31st May 2021

2021/62/091239/W – Redevelopment of 410 & 412 Birkby Road, Huddersfield, HD2 2DN

Proposed Site Layout Plan

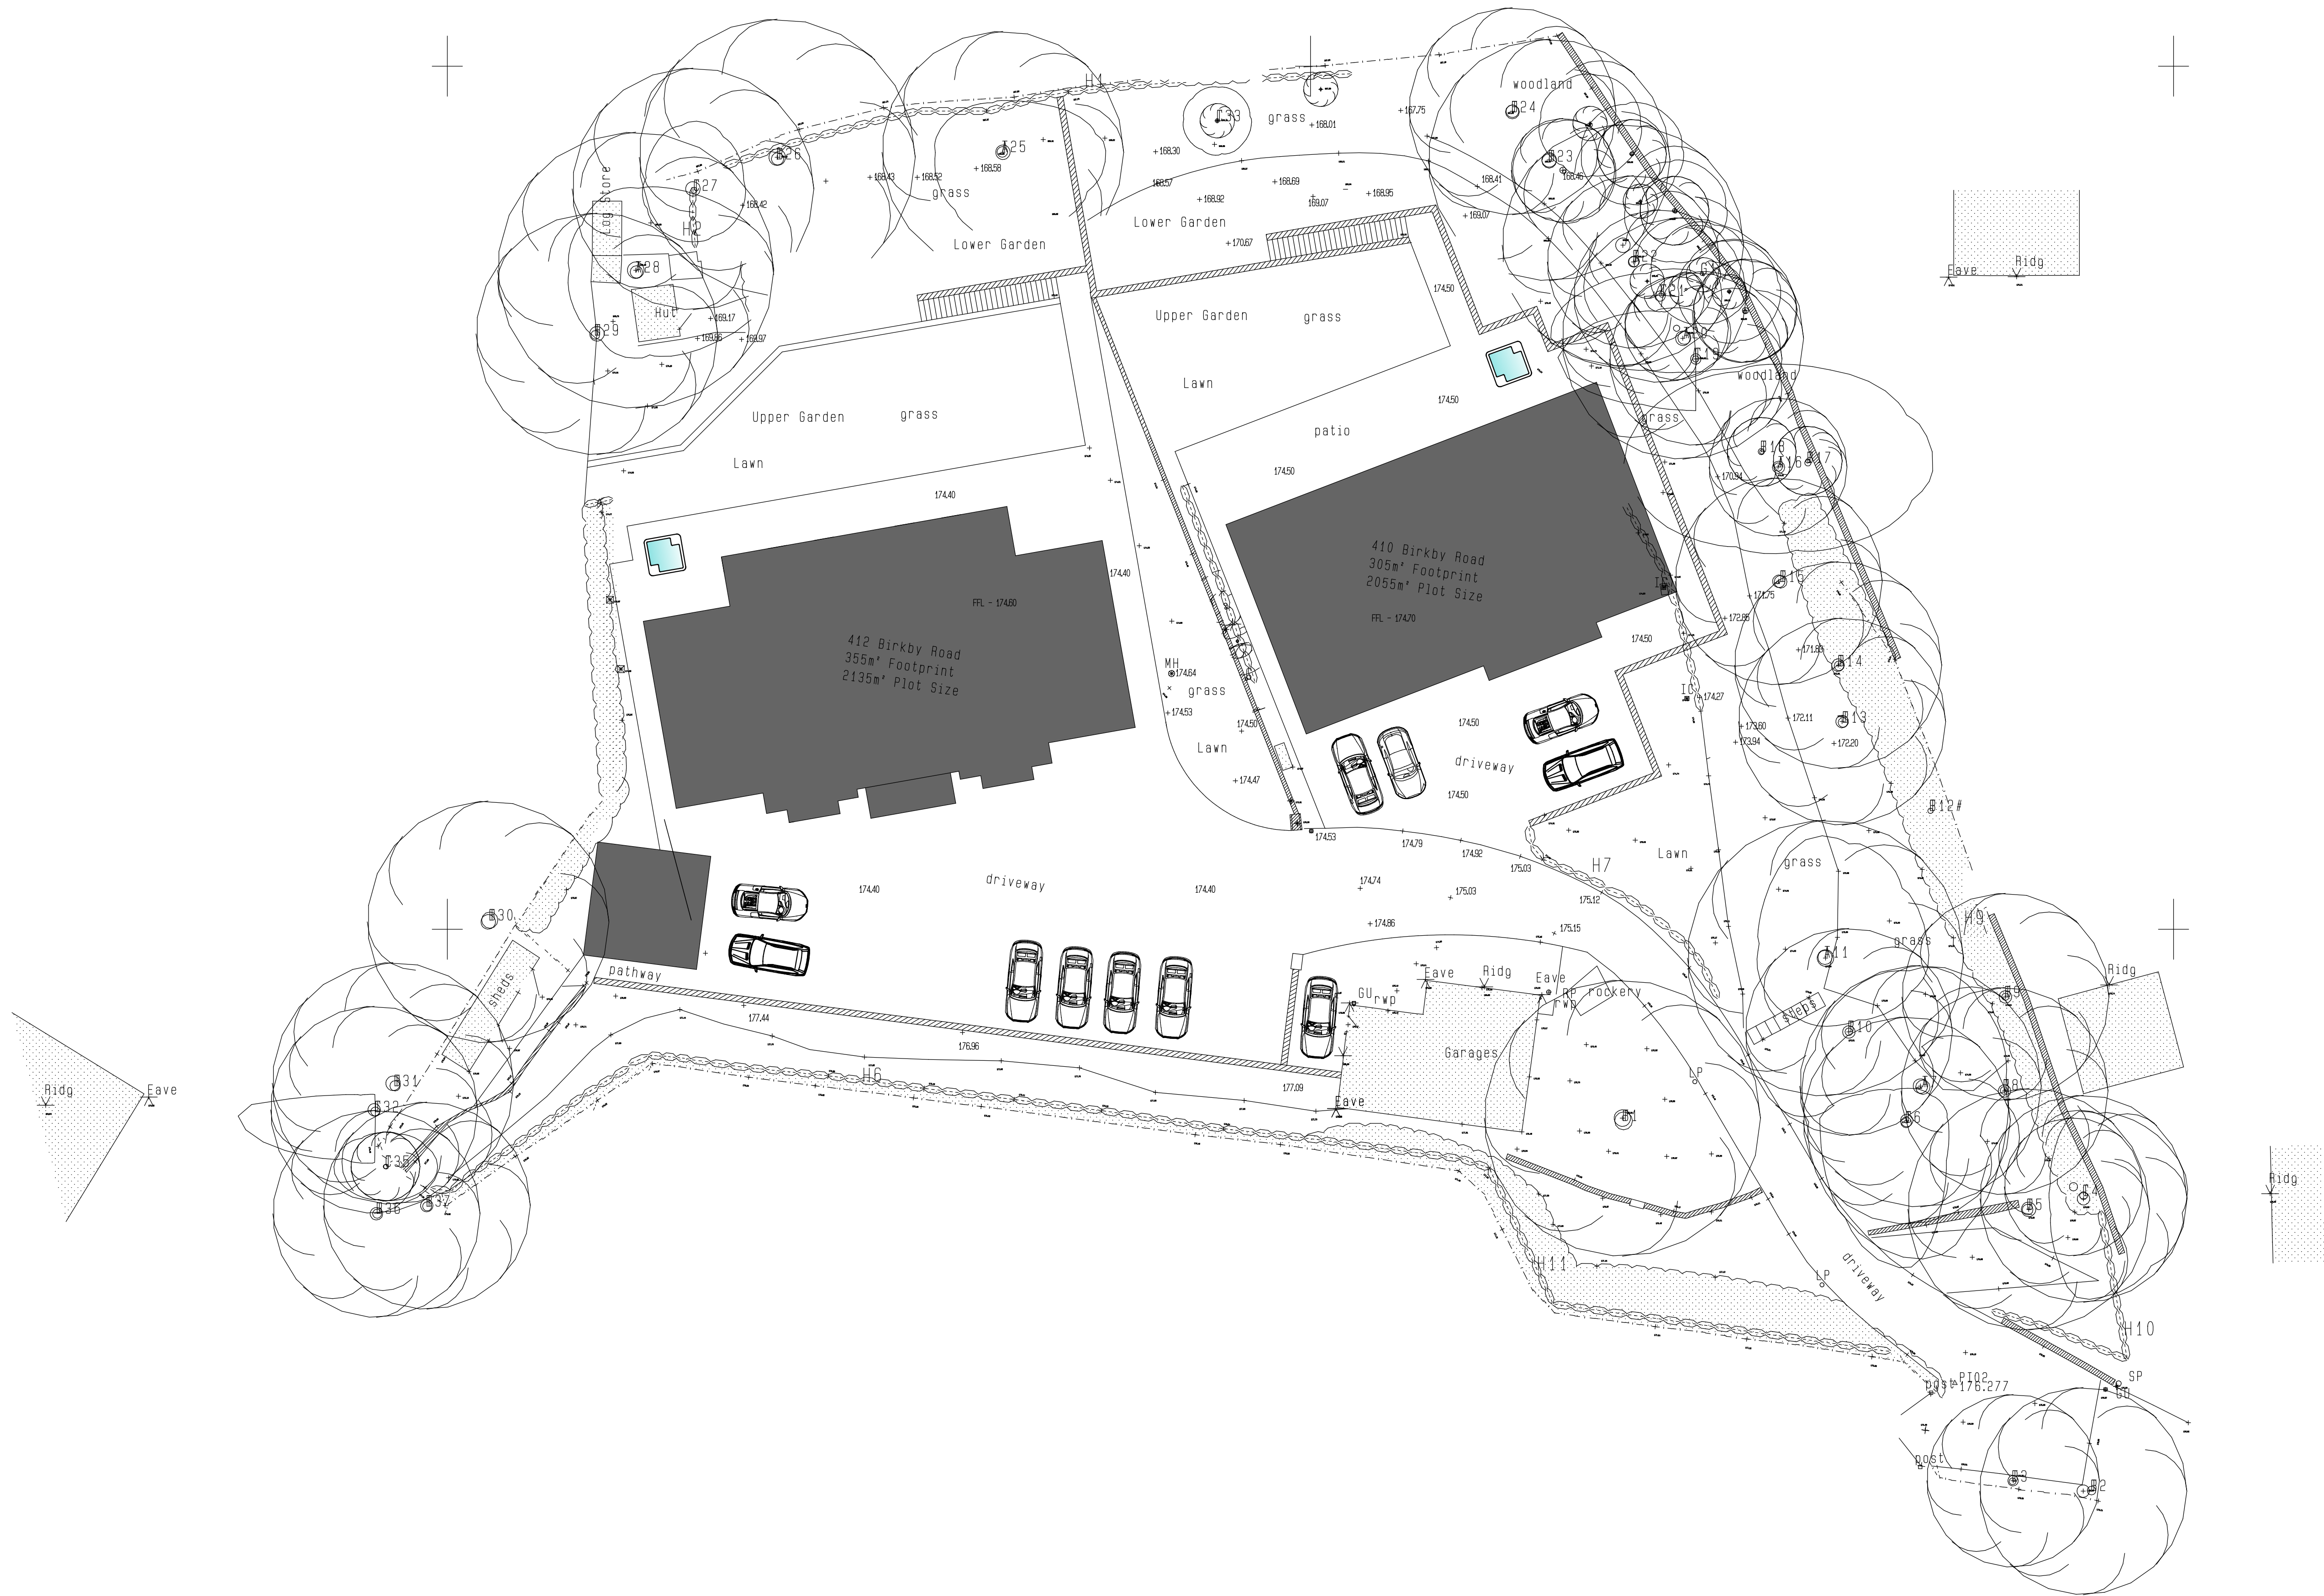
The hatched area directly adjoins the wall of the existing house at 410 Birkby Road, and the proposed development would significantly breach the protected area, in respect of the new house itself and even more so the very substantial retaining wall which would be required. Furthermore, construction of the retaining wall would require access for heavy machinery across virtually the whole of the protected area, causing severe damage to the roots of the trees.

The proposed new house at 410 Birkby Road, the ground level of which is around 4 metres above that of our home, would be both closer to us and much higher than the existing property, in each case by several metres.

The retaining wall would completely change the visual aspect of the property, replacing woodland vegetation with a substantial concrete wall, utterly out of keeping with the existing environment.

- The proposal to include office (or possibly living?) accommodation above a very substantial new garage, together with the proposal for a large number of additional parking spaces, would add to the over-development of the site and potentially constitute a change of use for the properties. They would also risk significantly increasing traffic flow on the lane from Birkby Road, not only inconveniencing neighbours but potentially causing congestion on Birkby Road close to the junction with Halifax Road, particularly at peak times.

Front Elevation

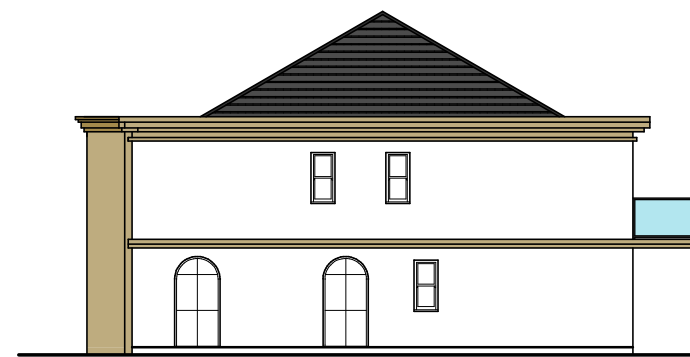
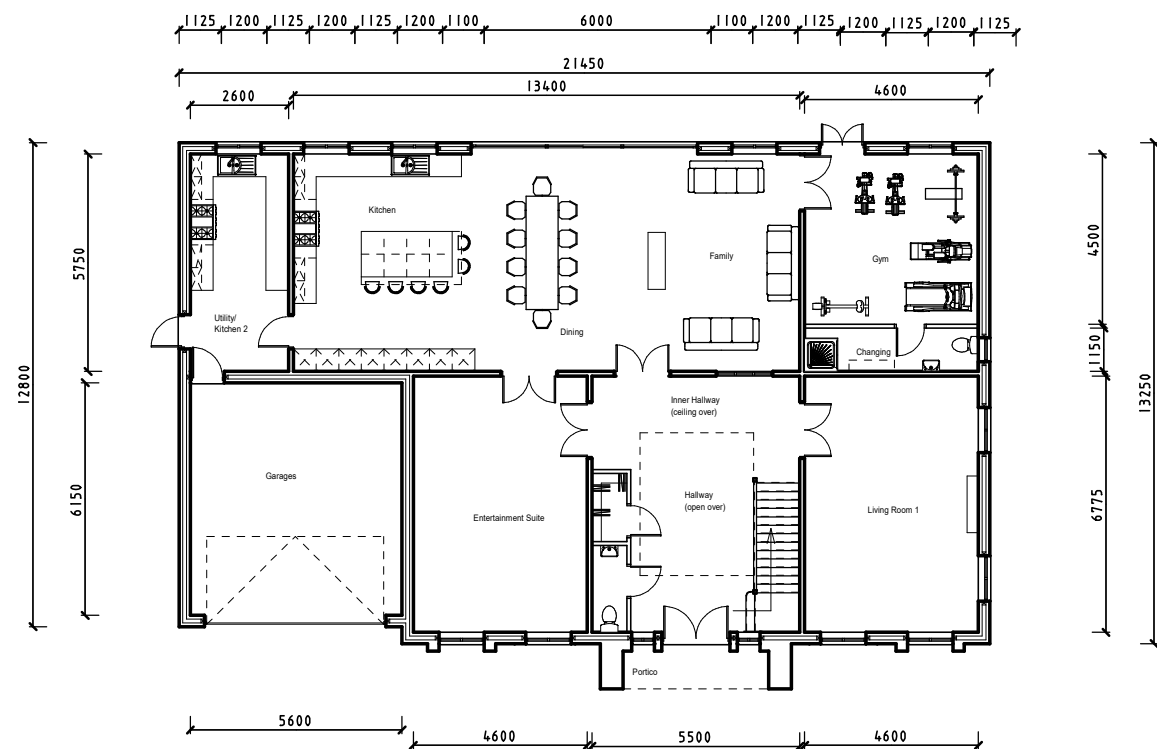
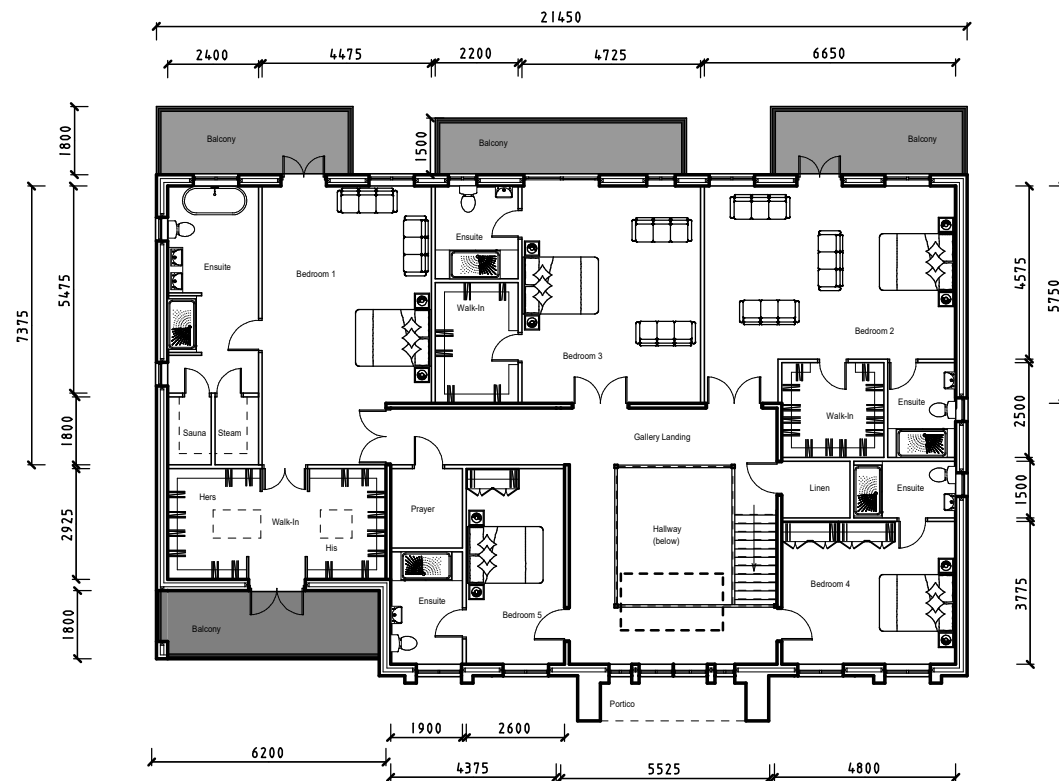
The new property would be 3-4 metres higher than existing and would replace the current dormer bungalow with an additional storey and a much more substantial roof.

The scale and massing of the new house would be completely overbearing and would visually dominate our house and garden, especially from November to April when the trees are not in leaf. This is clearly contrary to the intention of the original 2002 permission for the construction of a bungalow. We strongly contend that only a similarly sized and situated bungalow should be permitted on this site in the future, for the same reasons that applied in the original decision.

In addition, the ground floor windows on the eastern elevation and the first floor glazed balcony would intrude significantly on our privacy, giving direct sight into not only our garden but also into our principal upstairs and downstairs rooms, especially during the winter months. The addition of the proposed windows would be directly contrary to the provisions of the original 2002 planning permission and the 2013 permission relating to 410 Birkby Road, both of which include clauses prohibiting the insertion of additional windows and openings in the dwelling. (2013/70/93405/W Paragraph 4 - "No additional windows or openings shall be inserted in the side elevations of the dwelling hereby approved." See also 2002/62/92426/W Paragraph 9)
